16 February 2022

Our Ref: R/2017/17/H
File No: 2022/060463
Your Ref: SSD-8671-MOD-7

SSD 8671 MOD 7 – Additional commercial uses and design amendments – Advice on Modification

Figure 2: proposed eastern façade (Plan A-222, 24/01/22)

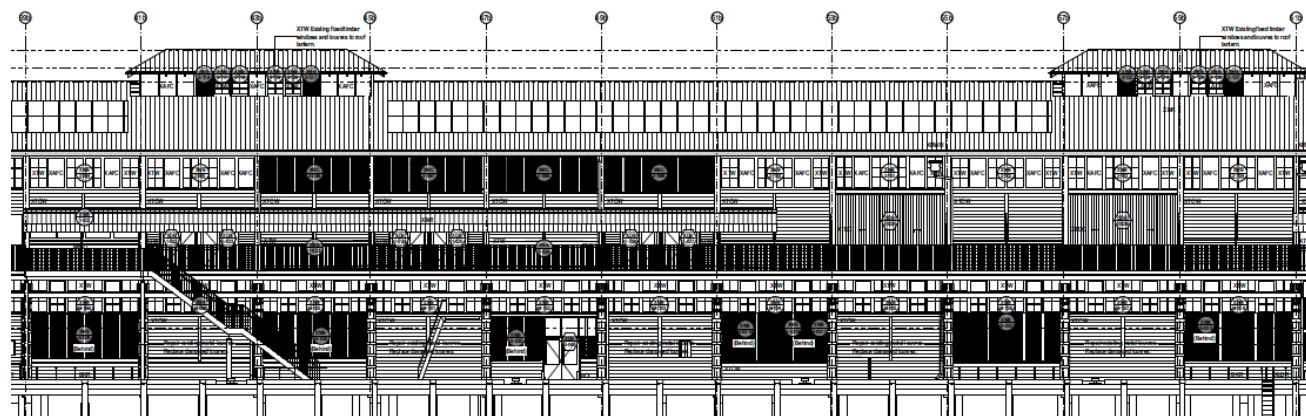
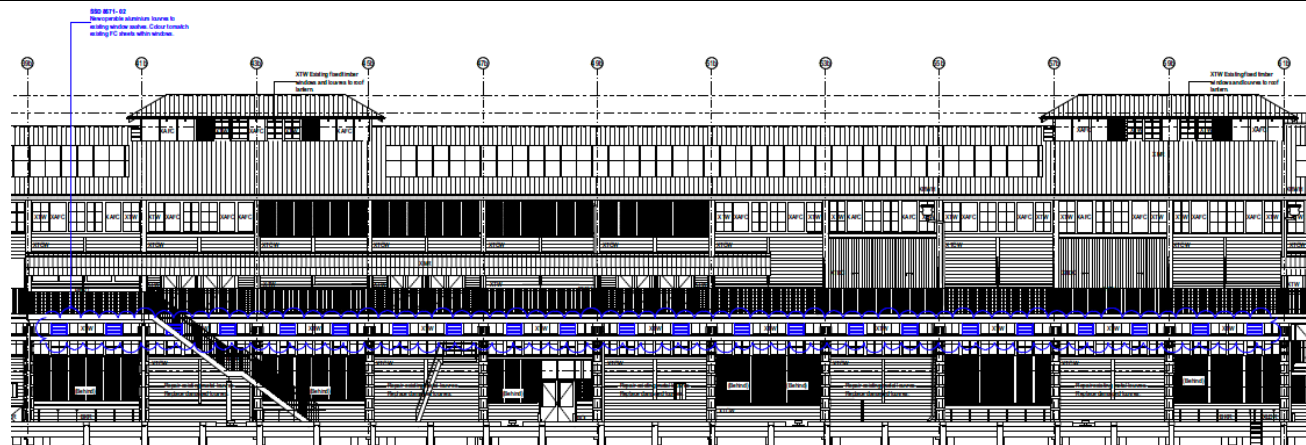
The high level louvres to the ground floor western facade of Wharf 4/5 will replace non-significant fibre cement sheeting, fit within the existing window

frames and match the colour to reduce their visual impact. This will have a minor but acceptable heritage impact provided the *Recommendations for Proposed Louvres to Western Facade of Wharf 4/5* in Section 4.2 of the HIS, prepared by Tropman and Tropman Architects dated January 2022 are imposed as a condition in any consent granted.

Figure 2: proposed eastern façade (Plan A-222, 24/01/22)

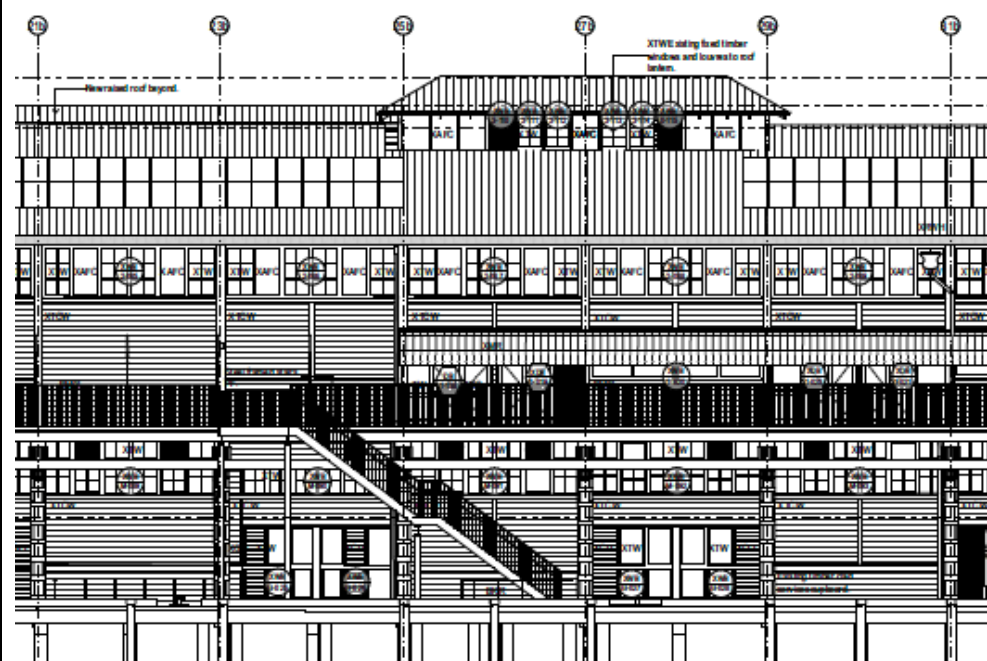
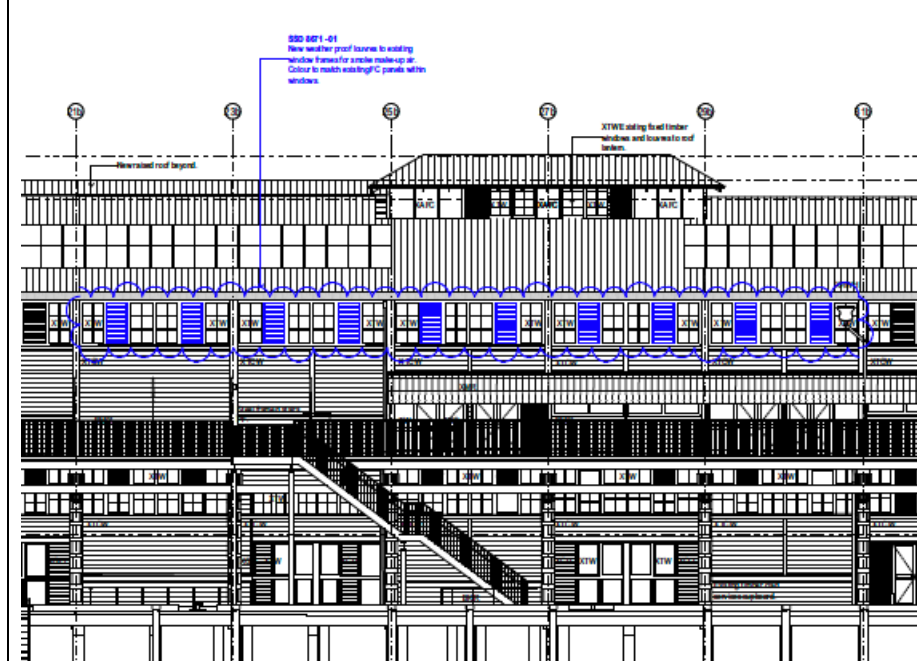
The high-level louvres on Level 1 will be aluminium and will be painted to match the colour of the existing fibre cement sheeting to reduce their visual impacts. This will have a minor but acceptable heritage impact provided the *Recommendations for Proposed Louvres to Western Facade of Wharf 4/5* in Section 4.2 of the HIS, prepared by Tropman and Tropman Architects dated January 2022 are imposed as a condition in any consent granted.

Figure 6: Ground Floor Plan of Shore Shed 4/5 (east) showing proposed upgrades to Commercial 3 and 4.

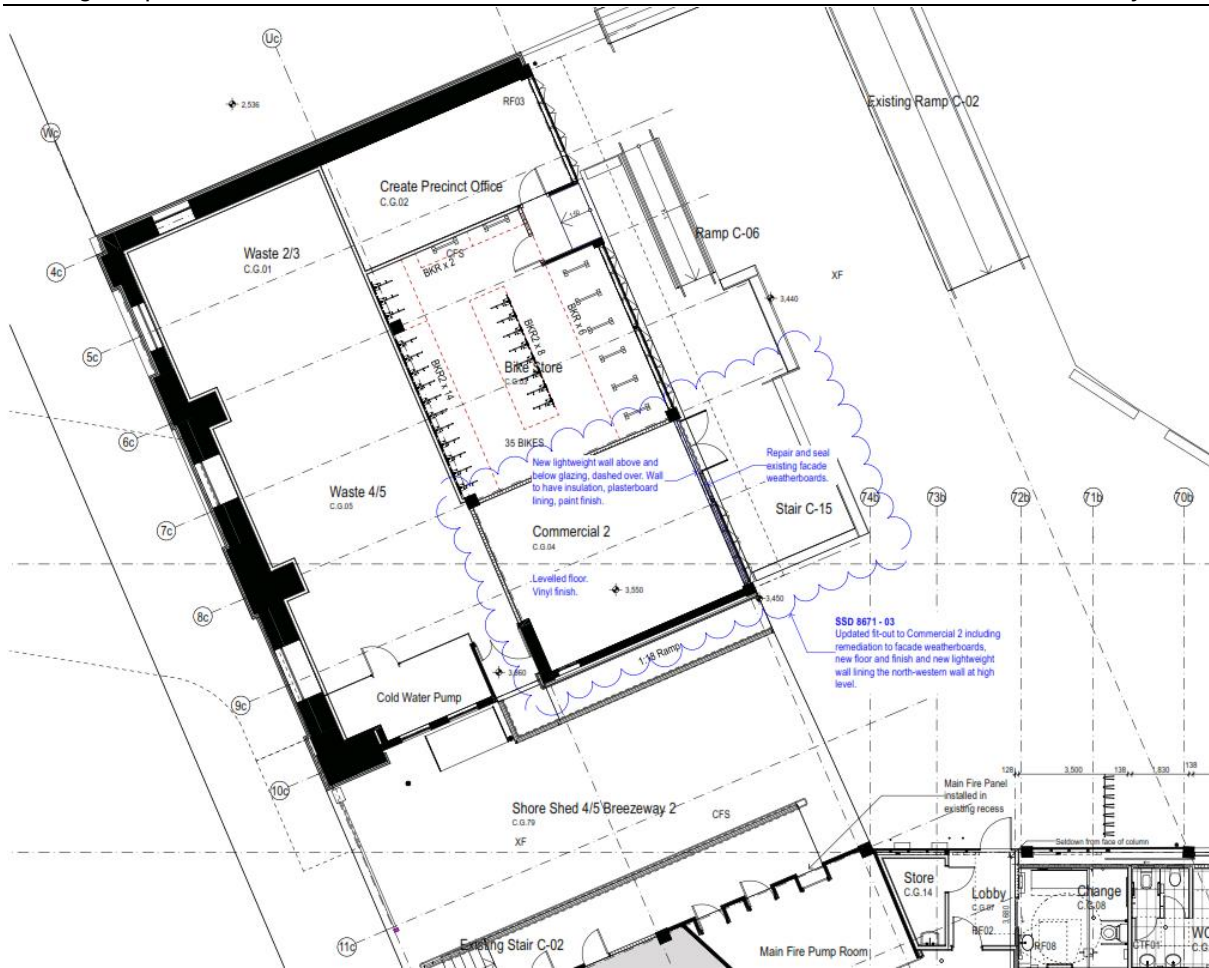
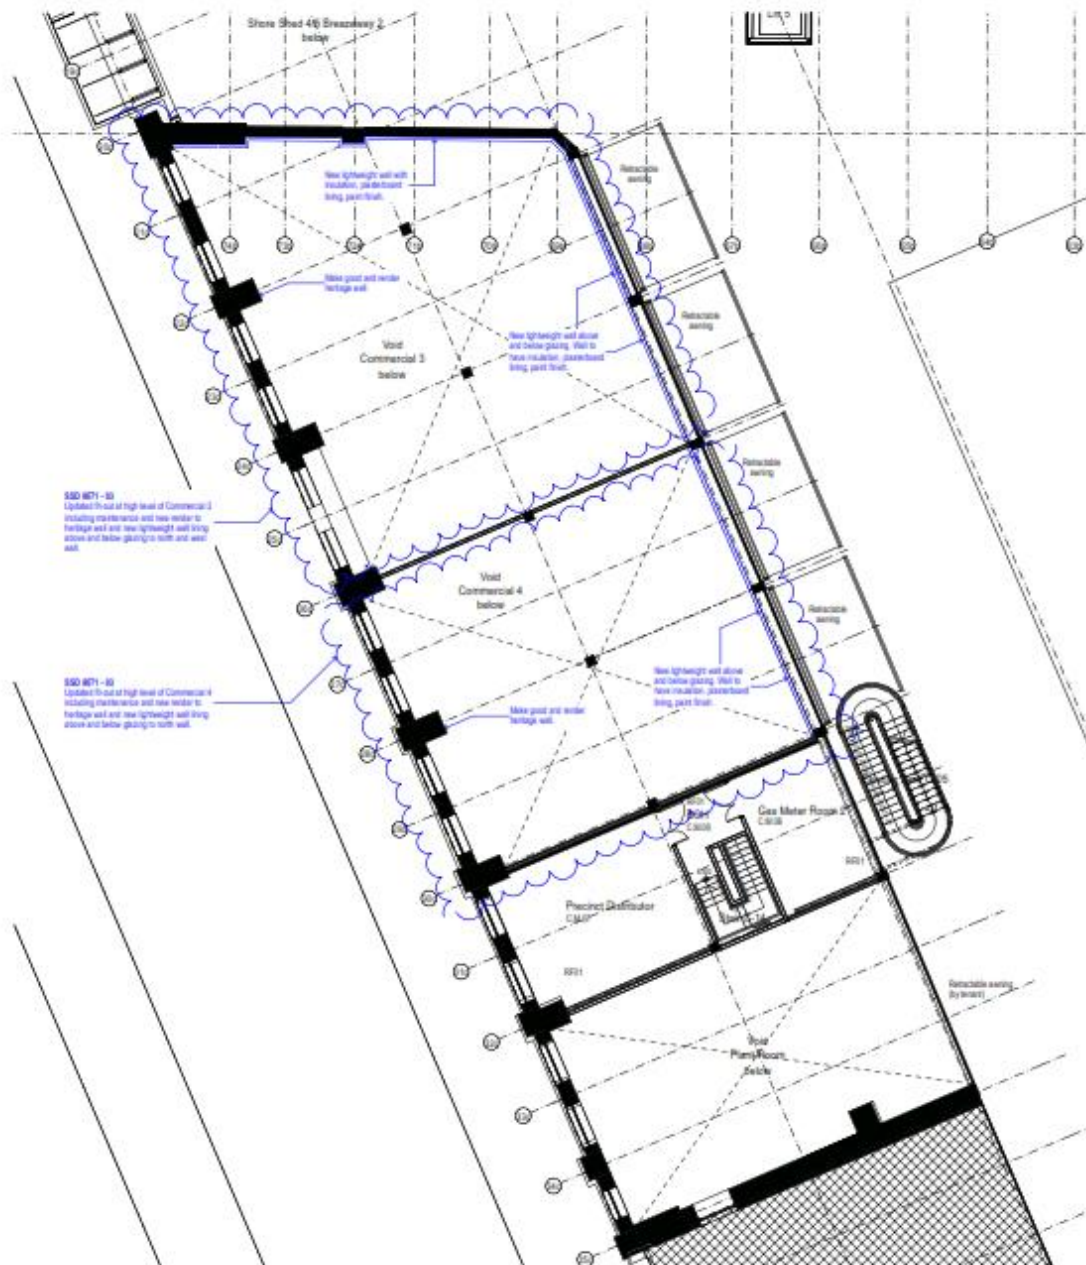
The additional uses will have a neutral impact on the heritage fabric, however, the associated fitout has the potential to have adverse impacts on significant fabric and spaces. To ensure such impacts are minimised, the *Recommendations for Proposed Fit-out Upgrade to Commercial 2, 3 and 4* in Section 4.3 of the submitted Heritage Impact Statement (HIS) prepared by Tropman and Tropman Architects dated January 2022 are recommend to be included as a condition of consent.
